**WELWYN HATFIELD BOROUGH COUNCIL
EXECUTIVE DIRECTOR - PLANNING, PUBLIC PROTECTION AND GOVERNANCE**

DELEGATED APPLICATION

Application No: 6/2020/1038/HOUSE
Location: 87 Bramble Road, Hatfield, AL10 9SB
Proposal: Erection of part single/part two storey rear extension, single storey front extension, new pitch roof over side addition and alterations to openings
Officer: Mr David Elmore

Recommendation: Granted

DRAWING TITLE
Proposed Block Plan and Proposed Drawings

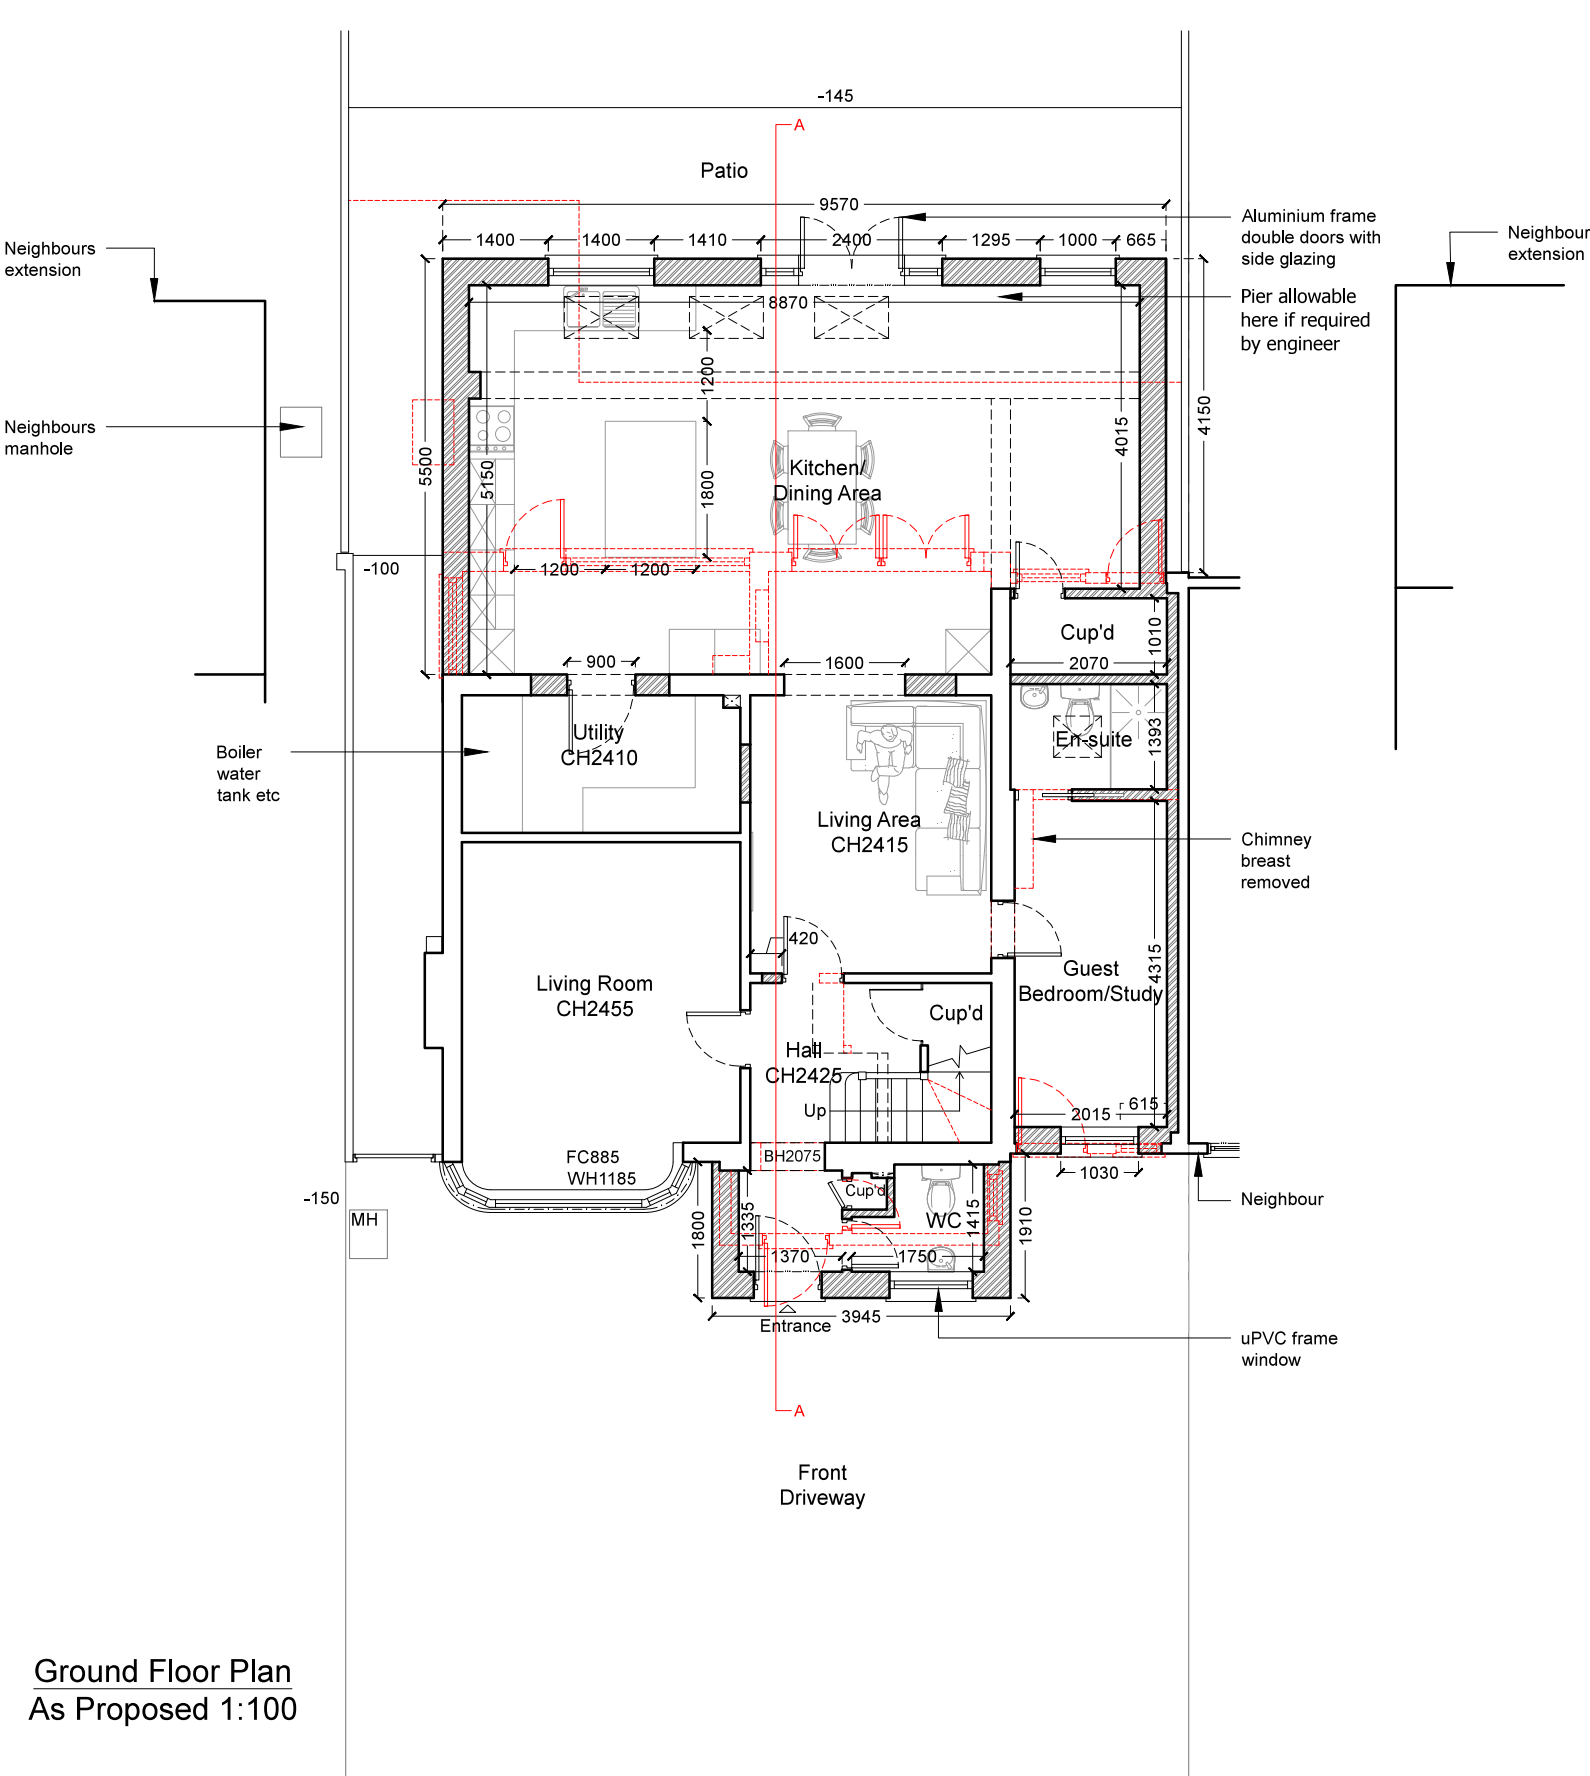
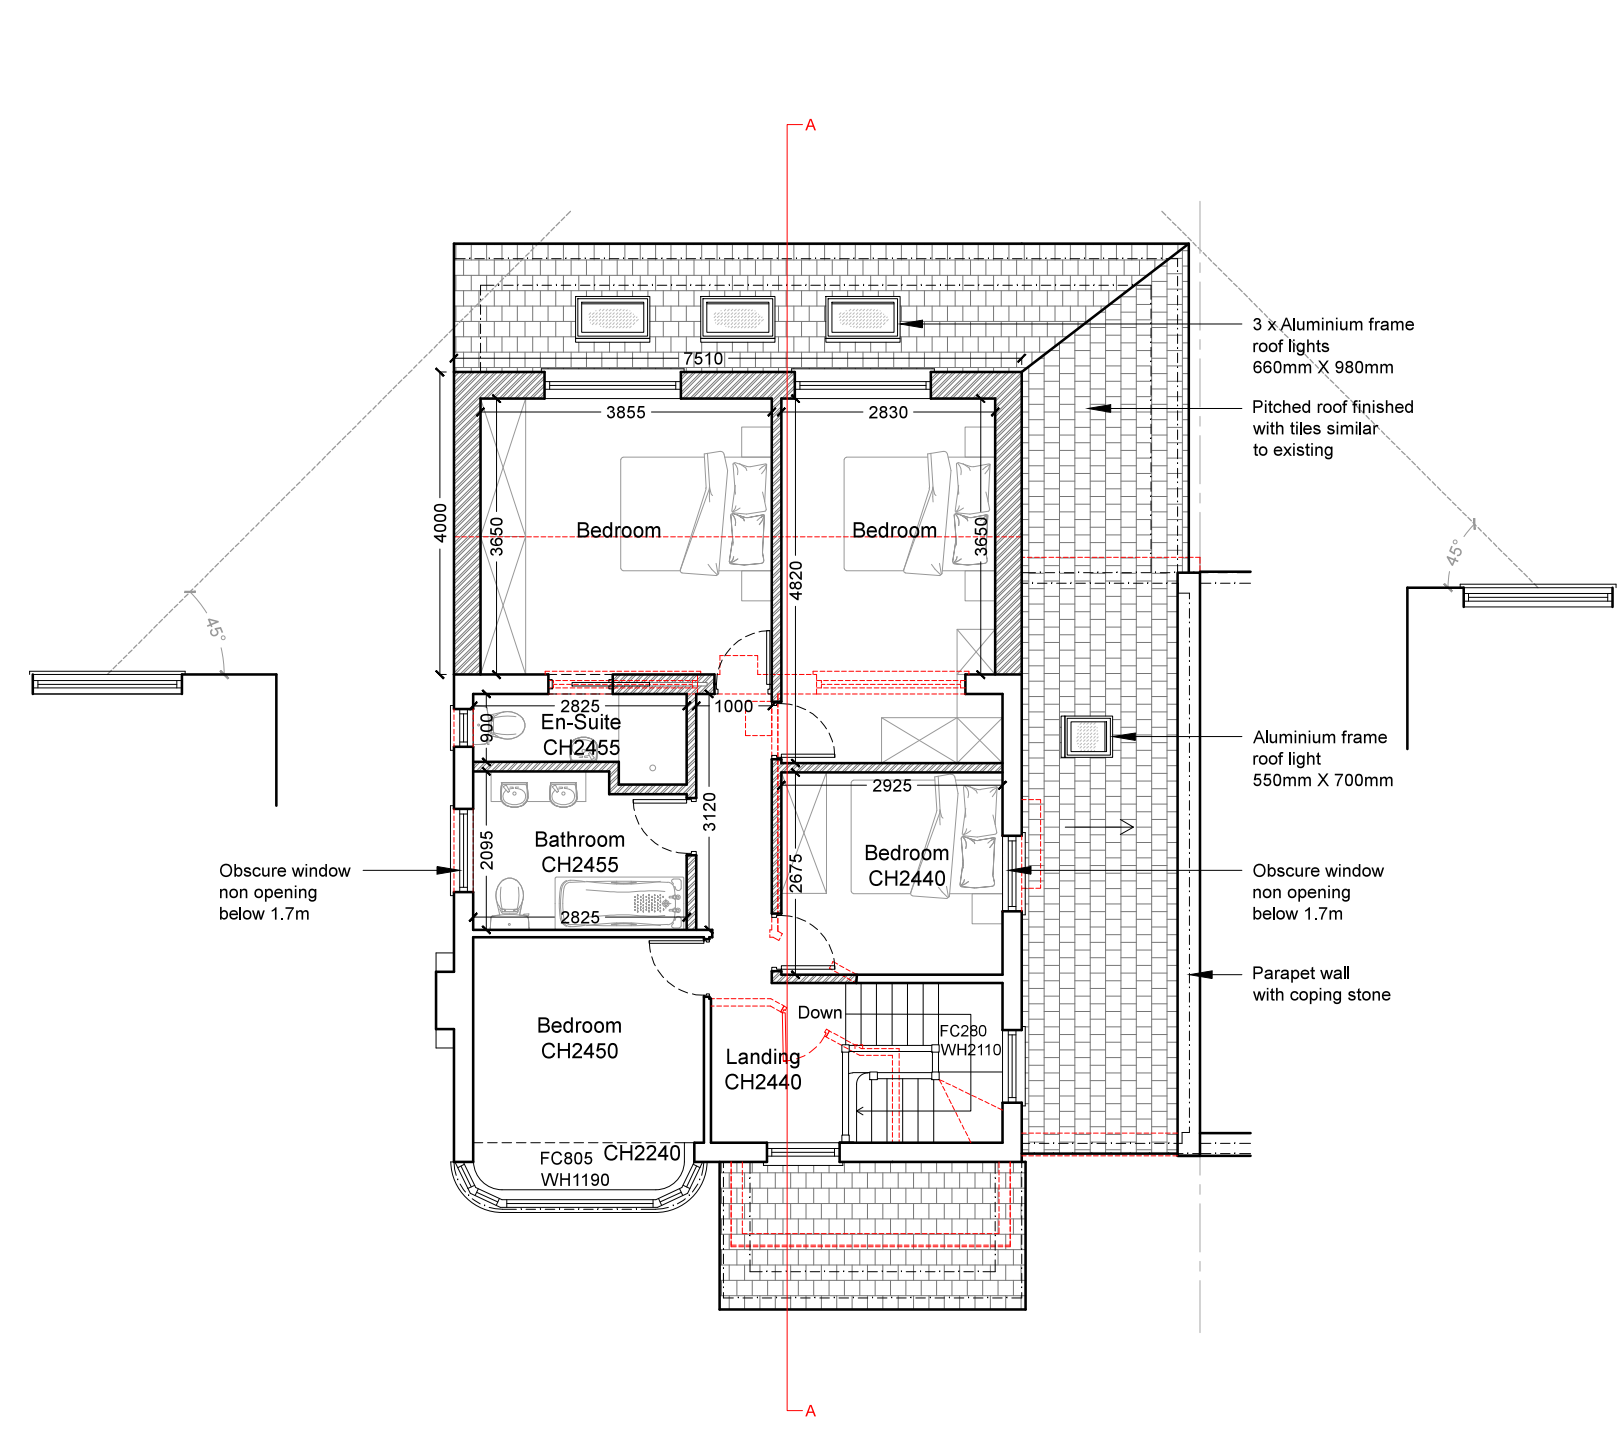
The proposed elevations annotate that the external materials of the proposed extensions would be similar to existing. Only matching external materials will retain the existing character and appearance of the dwelling and this can be secured through planning condition.

1. Notwithstanding submitted drawing number 1751RM_HH:SH2 Revision 0, the render, roof tile, windows, detailing, guttering, soffits and other external decorations of the approved extension must match the existing dwelling in relation to colour and texture.

Side Elevation
As Proposed 1:100

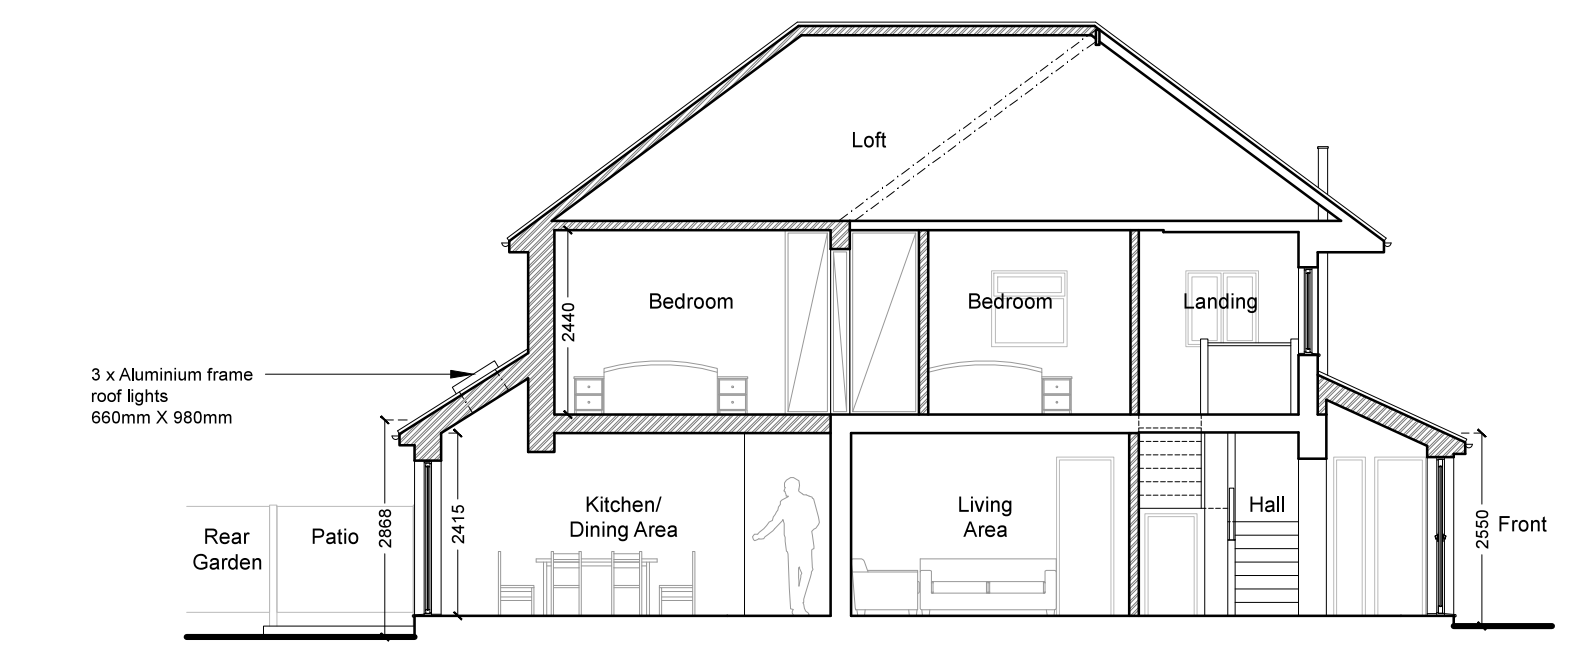
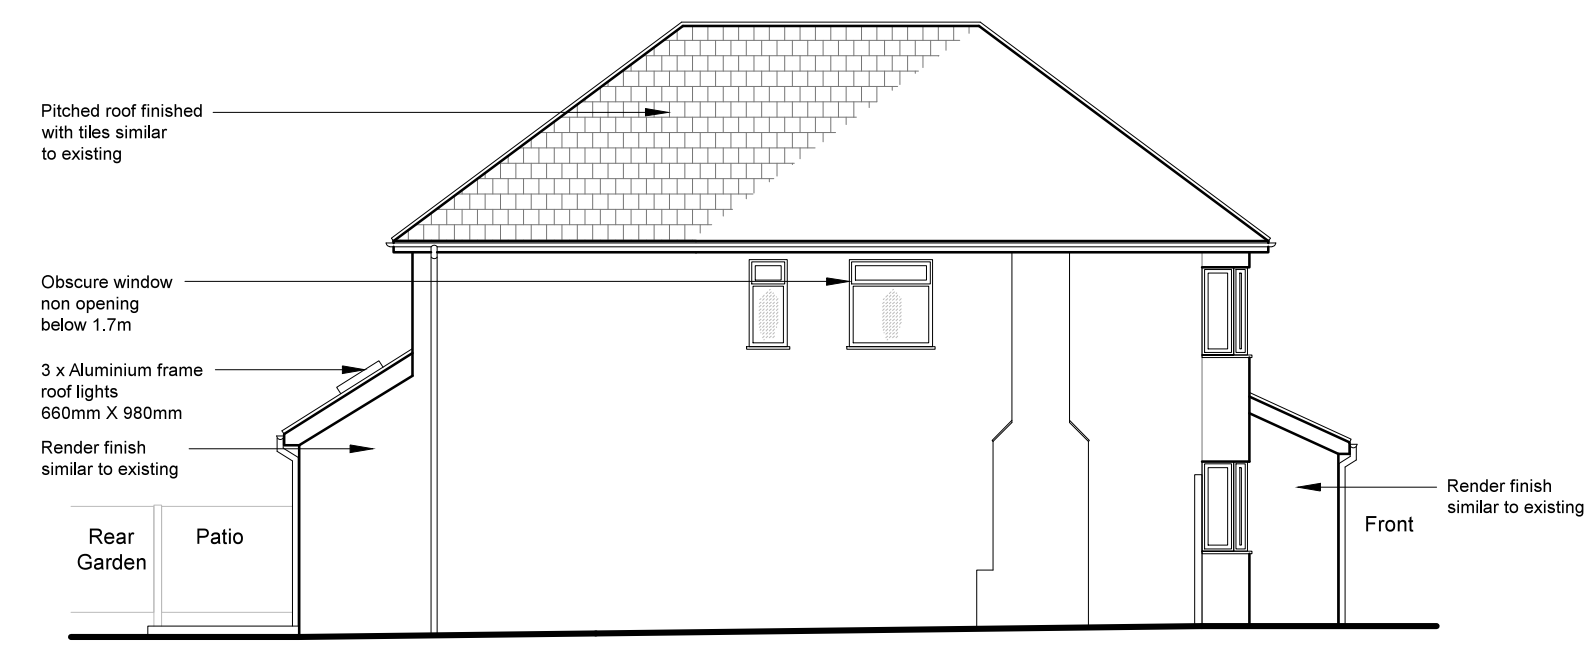
The proposal includes two first floor side window facing number 85 which would serve a bathroom an en-suite. The bathroom window is annotated to be obscured and non-opening below 1.7 metres however the en-suite window is not. This measure will prevent any potential for overlooking and such a requirement for the en-suite window can be secured through planning condition.

The proposal includes two first floor side window facing number 89 which would serve a bedroom. This window is annotated to be obscured and non-opening below 1.7 metres and this measure will prevent any potential for overlooking.

2. The upper floor side elevation windows hereby approved must be obscure-glazed and non-opening unless the parts of the window which can be opened are more than 1.7 metres above the floor of the room in which the window is installed, and must be retained in that form thereafter.
